**From:** [Virginia Waller](#)  
**To:** [Robin Proebsting](#); [Scott Greenberg](#)  
**Cc:** [Debbie Bertlin](#); [Cindy Goodwin](#); [Julie Underwood](#)  
**Subject:** Re: Thrift Shop and Parking Expansion  
**Date:** Friday, January 27, 2017 10:12:50 AM

**RESPONSE:** It sounds like the document you're referring to is the one labeled "Site Paving Plan", on which reinforced turf is shown alongside the existing access path on the west side (i.e. away from the parking lot) near SE 34th, then east of the existing path, closer to the trees as it bends heading northward. It appears that this plan is showing how adequate fire access (e.g. lanes wide enough for a fire vehicle to drive, turns of an angle a fire vehicle could make, fire lanes close enough to every point in the building etc.) could conceivably be provided.

SHEET NAME
SITE AND PAVING PLAN

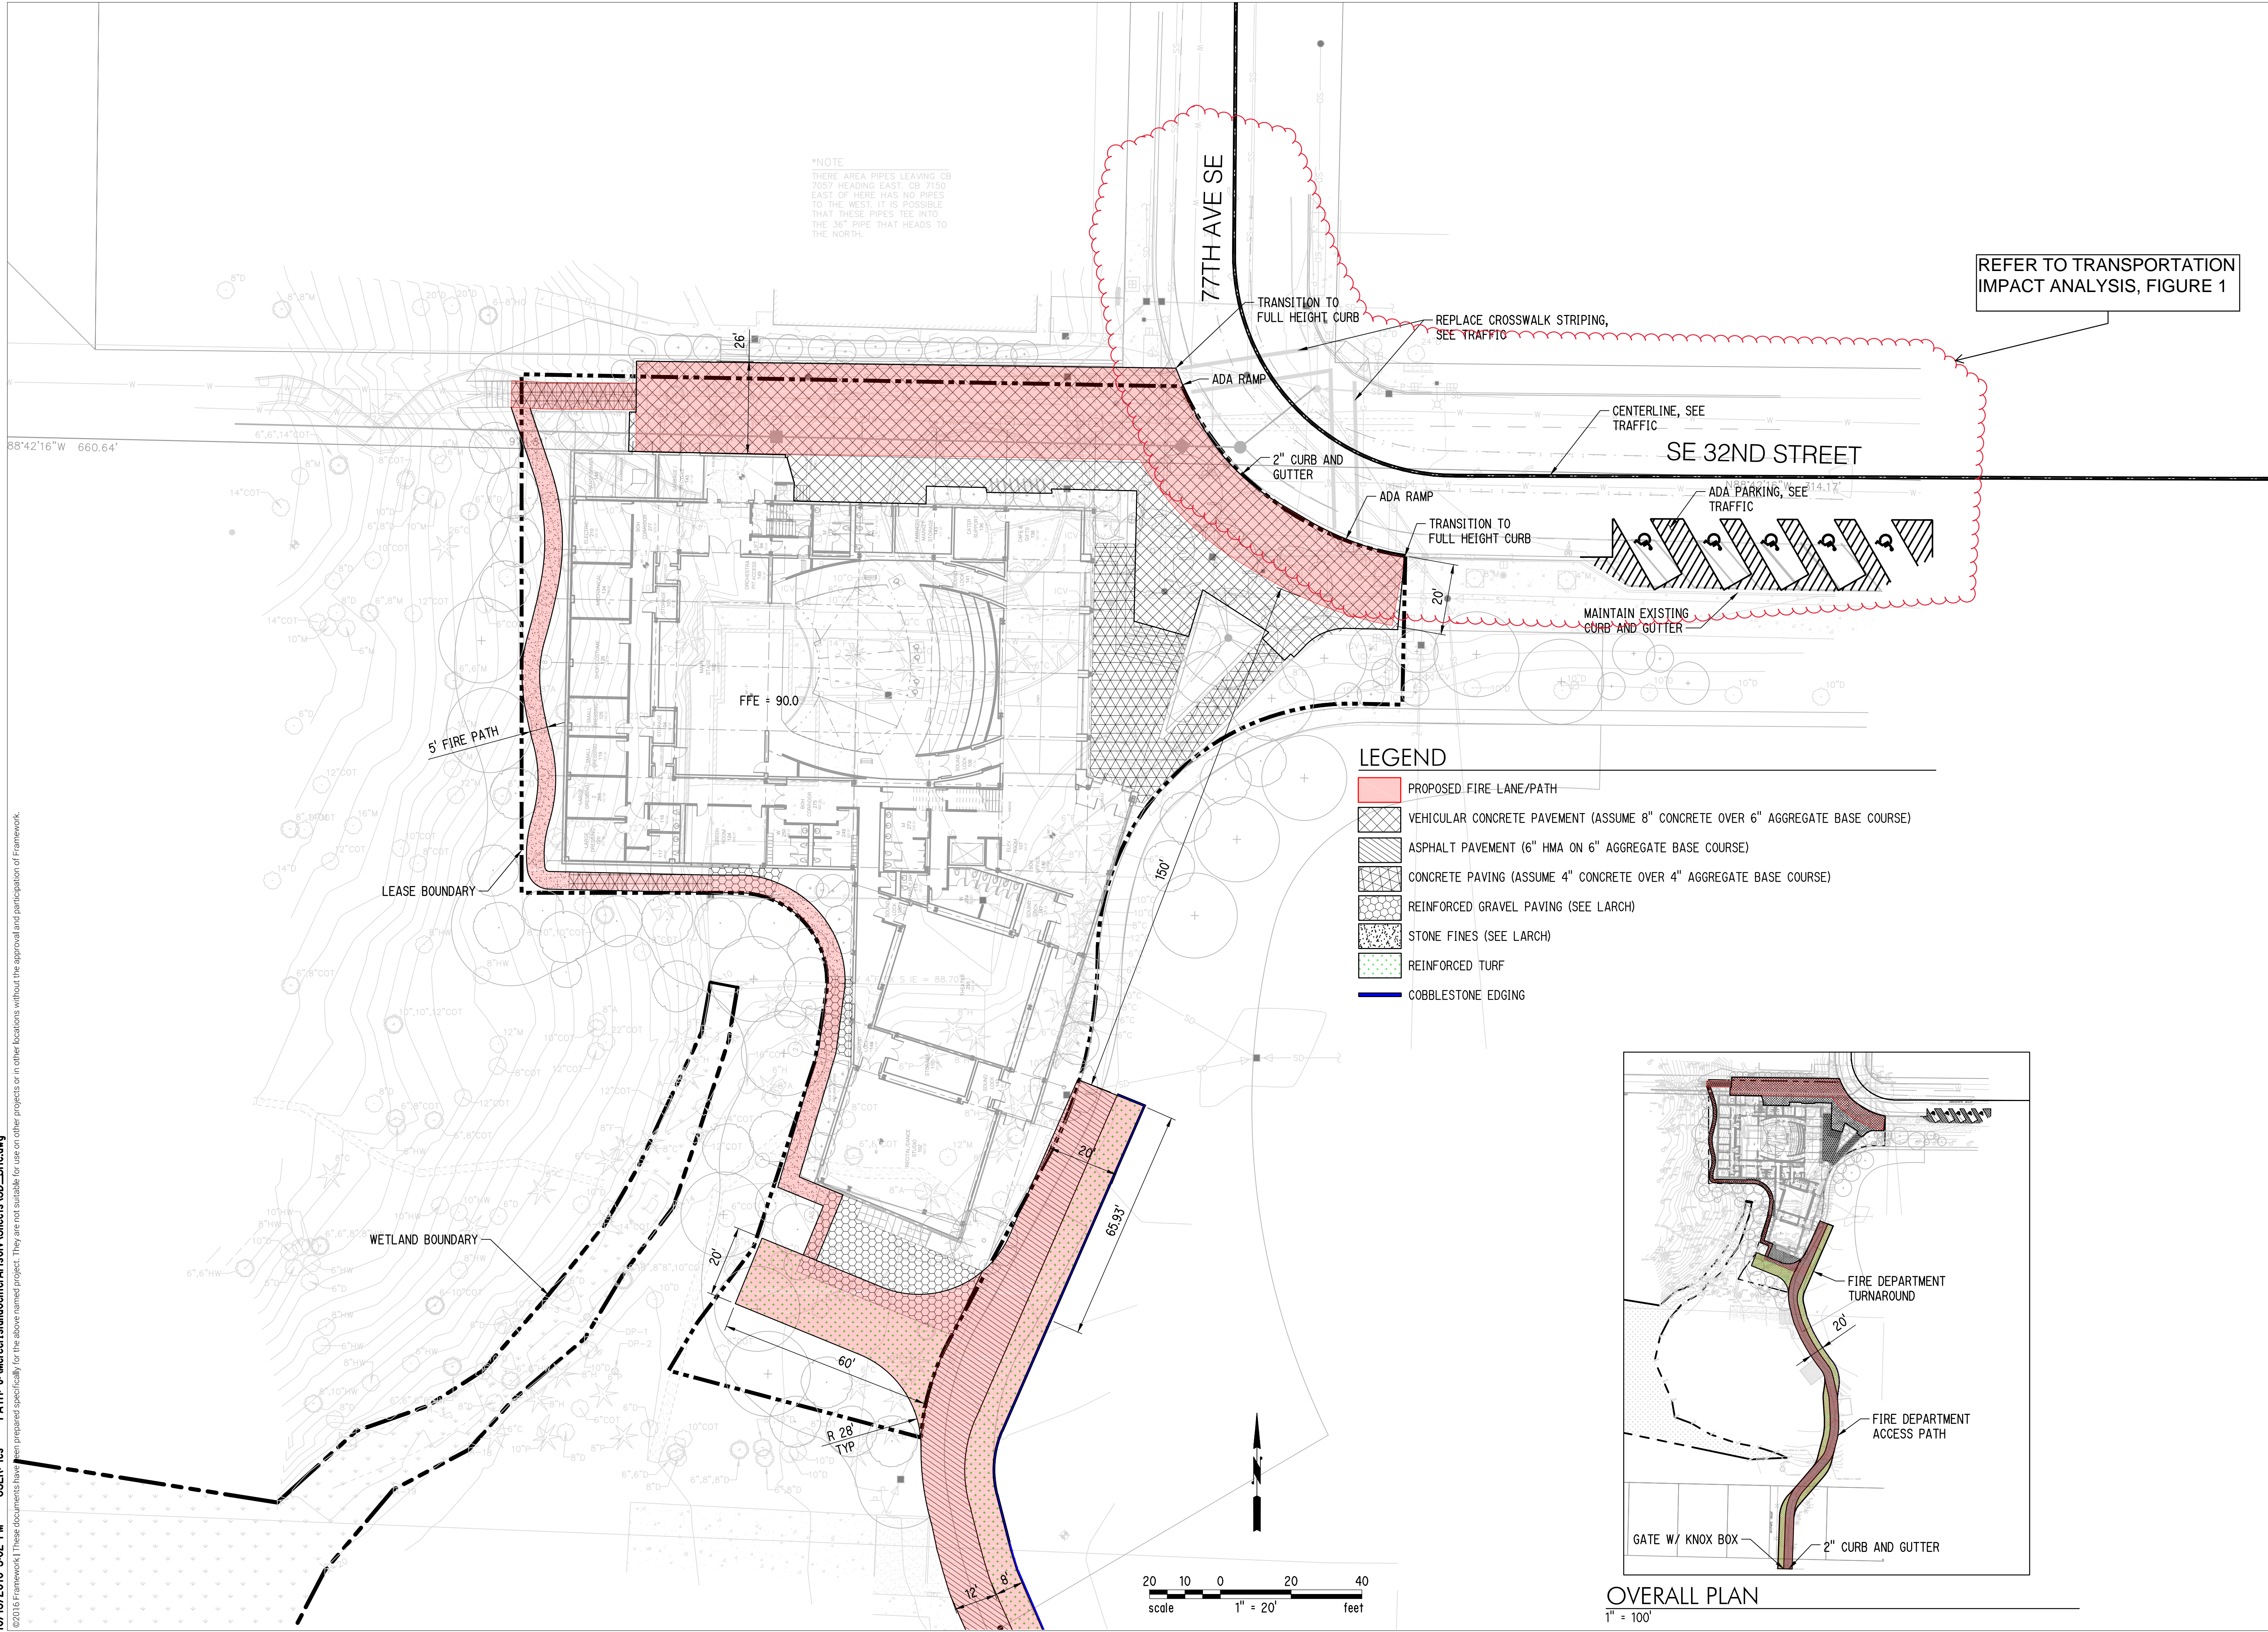
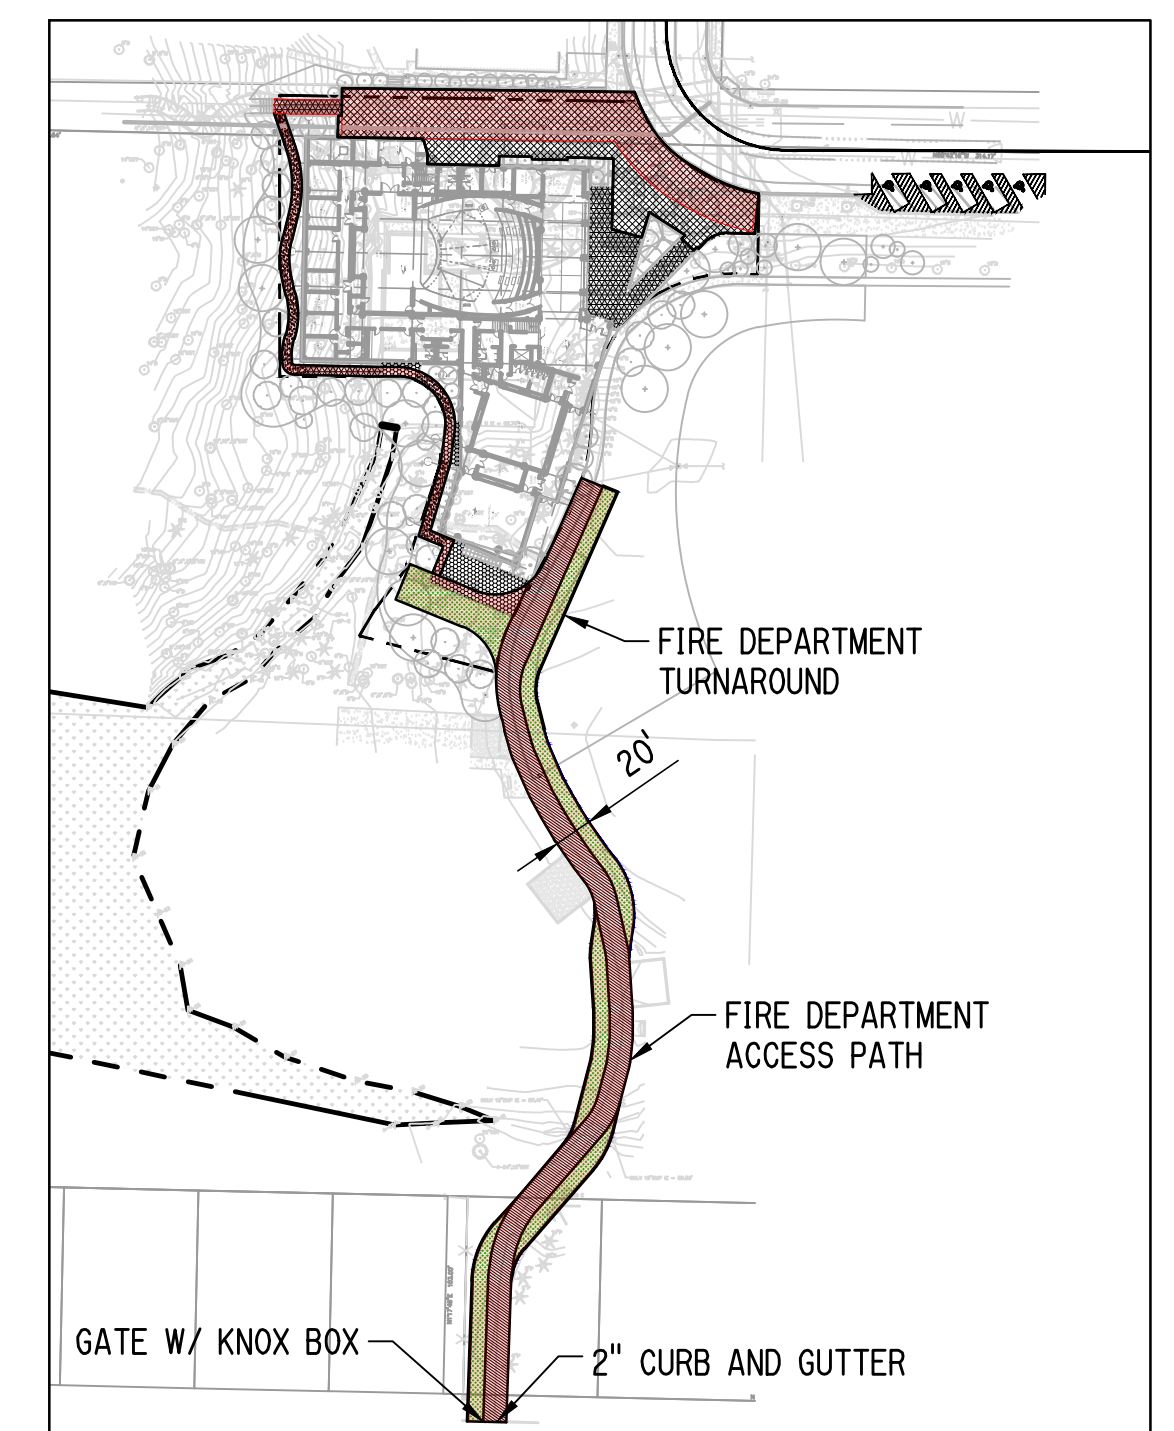
> I saw an updated MICA plan last week, which now includes a 20' wide fire road starting on 34th (in a residential neighborhood) and running alongside the edge of the Thrift Shop parking lot where there is now a walking path. To accommodate the proposed width, I wonder if some parking spaces might be impacted -- the pine trees will almost certainly need to be removed. And the newly-installed exercise equipment in the park will likely be impacted. The 2-lane road goes into the park, stopping just past the skate park.

> At this point, there is a ton of traffic that comes off 78th and into the Mercedale neighborhood. It is not fair to allow this to increase substantially because of MICA, and a fire lane dropoff will almost certainly attract users. Can the fire road be blocked off with a gate that only the fire department can open?

This is not the type of plan that would be used for street construction--it does not show enough detail for that purpose. It is possible that there could be impact to trees, however at this of review, staff are looking at conceptual plan. These do not have enough detail to provide a certain answer. The City does have codes pertaining to tree retention, and at the construction plan review stage, the applicant will need to show they are meeting tree retention codes.

**RESPONSE:** The site plan shows a gate at the south end of the fire access path (the SE 34th St side) and a "Knox Box", which is a system that allows a gate to be locked, but still allow for emergency access quickly. This indicates that the intent is to keep the gate locked but available for Fire Department access only.
